From: Nick Scott [REDACTED]
Sent: 08 September 2015 15:21
To: Planning
Cc: Alison Meeus; Derek Whittington
Subject: Planning Application BN/29/15/PL (Public Rights of Way Comments) F.A.O Richard Temple

Figure 4 - Public Rights of Way (PRoW) Network

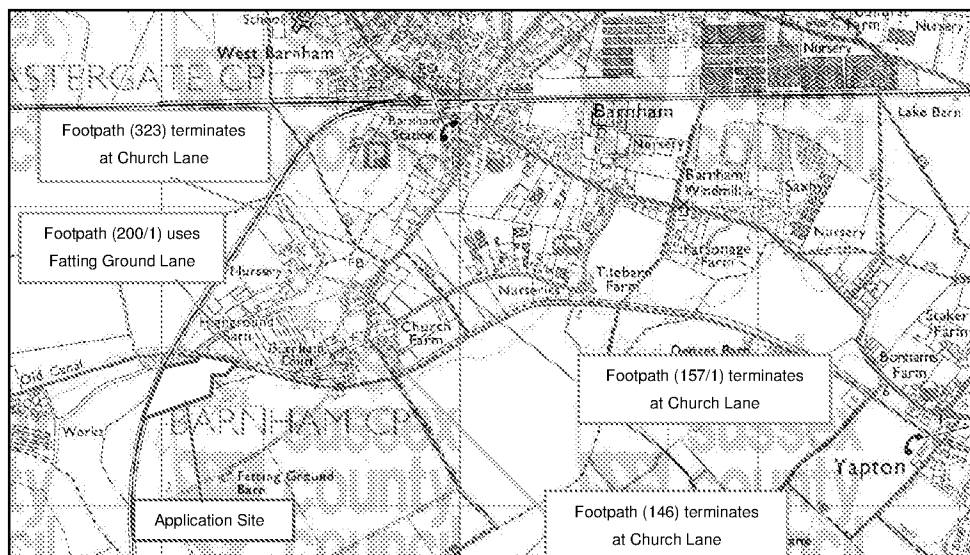
From a public right of way point of view clarity would also be welcome on what route of vehicular access will be available when travelling west from the red line, toward the site of the solar farm. The line of FP200/1 actually runs along the southern edge of the old canal and becomes a raised bank the further west it goes and it is hoped that the proposals are for vehicular access to be gained on the old northern bank of the canal, safely away from the legal line of the footpath and pedestrian users. This would seem the most sensible option as the footpath is not very wide but if this could be clarified that would be appreciated. If it was the case that access was being granted along the legal line of the footpath then surface

improvements would be required so the route was useable all year around, even though it was experiencing considerable vehicular use.

## FP146 & 200/1 - Felpham

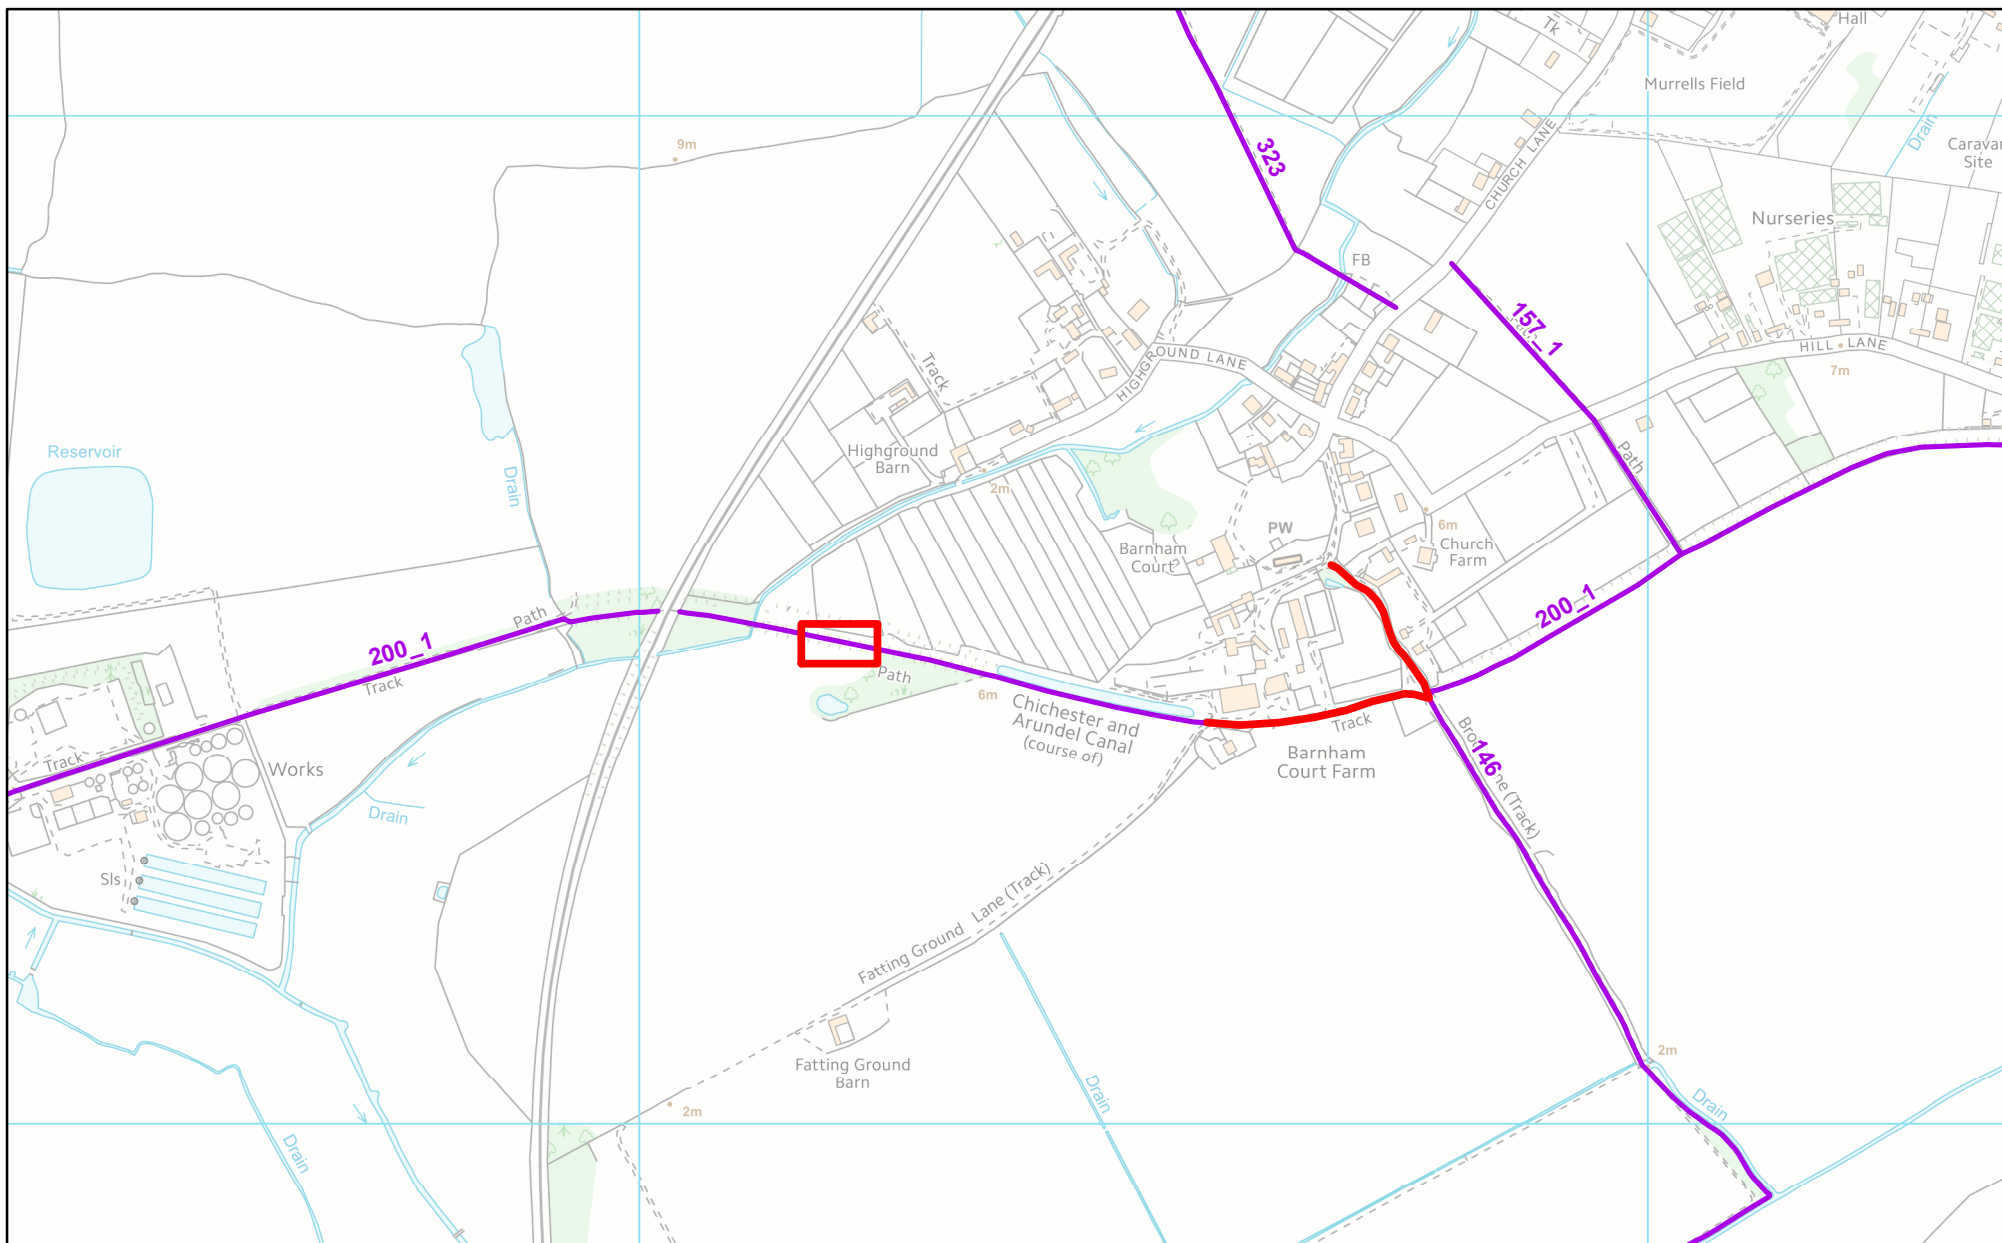
The final issue relating to the access itself would be the point it crosses FP200/1 (as shown roughly by the red square on the attached plan) into the actual site of the proposed solar farm. There is a clear crossing of the legal line of the footpath and due to the works taking a reasonably long time to be completed, and future access being required for maintenance it would be required for a stone surface to be laid at the point where the two routes cross so it is useable all year round even though vehicles are using it. If left as an unmade surface this route will become impassable to lawful pedestrian users when wet and this would be unacceptable. A specification for such surface improvements would have to be agreed with the PROW team at WSCC before works took place. At this crossing point where the access to the site and the public footpath cross, signage would be required informing that the public right takes precedent over the private vehicular right and also warning of the potential conflict along the entire east west section where vehicles will be moving close to lawful pedestrian traffic on the footpath.
